Jeanie Bourke - Re: Vignola proposed rail

The deck design we sent in with the permit application for Vignola included PT balustrade. We would like to upgrade this system to the stainless steel cable system that I have attached to this Email. Please let me know if you have any objections to this system>

032-V-016
Permit # 2011-12-2992

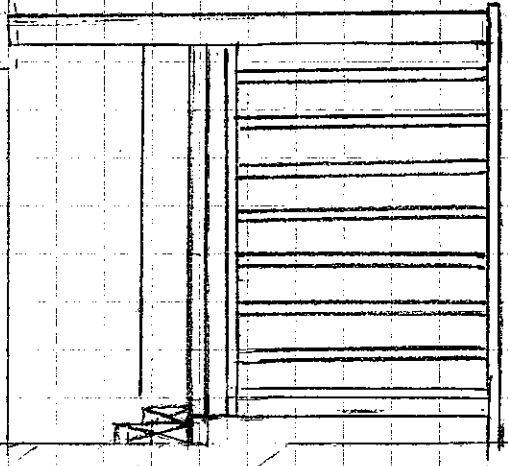
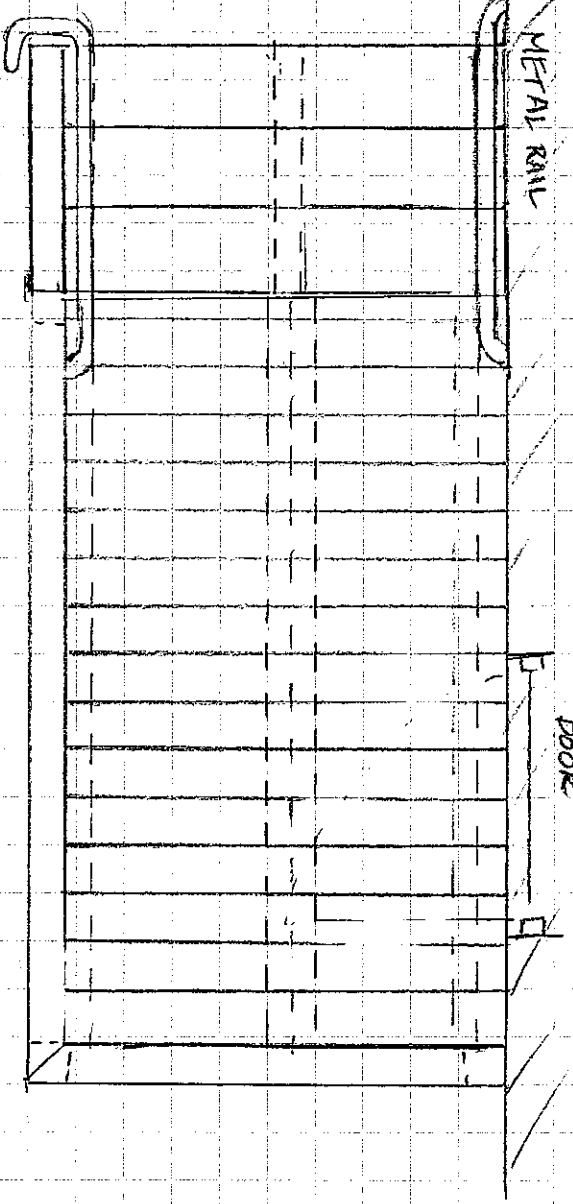
Thank you Aaron,
This new guardrail design will need to meet the structural loads and opening limitations as required by the IBC 2009.
I will file this document with the permit.
Jeanie
